Application No: M/123/21/PL
Site Address: 27 Central Drive Middleton-On-Sea PO22 7TT
Description of works: Erection of 1 No. 2 bed detached dwelling. This application is in CIL Zone 4 and is CIL liable as new dwelling.

Thank you for your internet representation made on 14th October 2021 which has been recorded as an objection with the comments as follows:

Site Plan

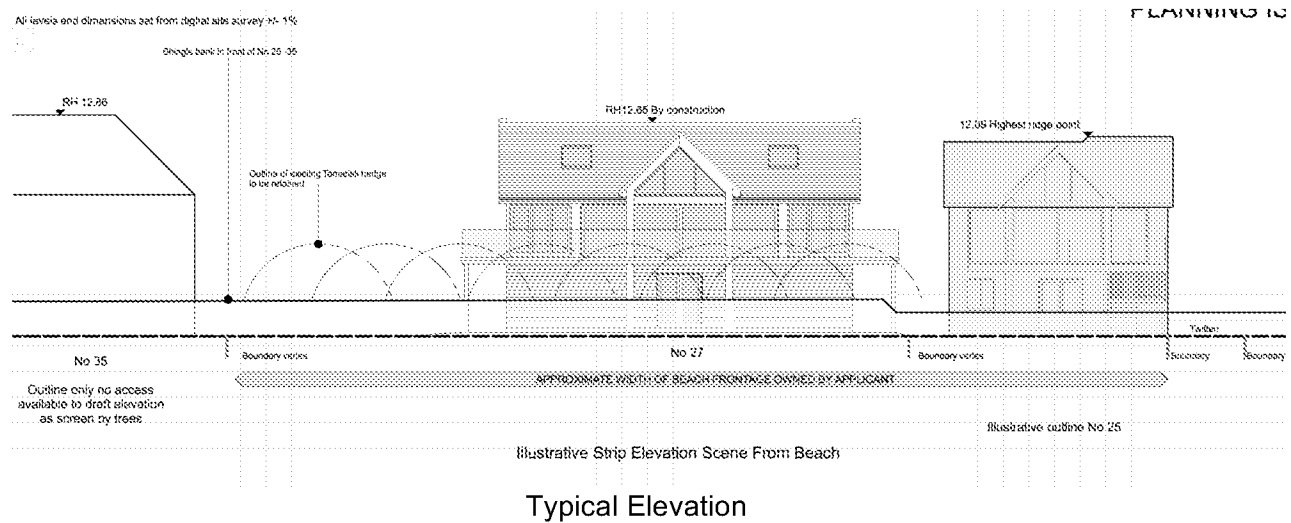
We appreciate that the height of this new property is proposed to be lower than the immediate property on the other side, no 35. However, you will see from the site plan that both 25 and 27 are much closer to the beach than no 35 and thus dominate the view from the beach. They are overbearing to beach users in a way that no 35, despite its additional height, is not.
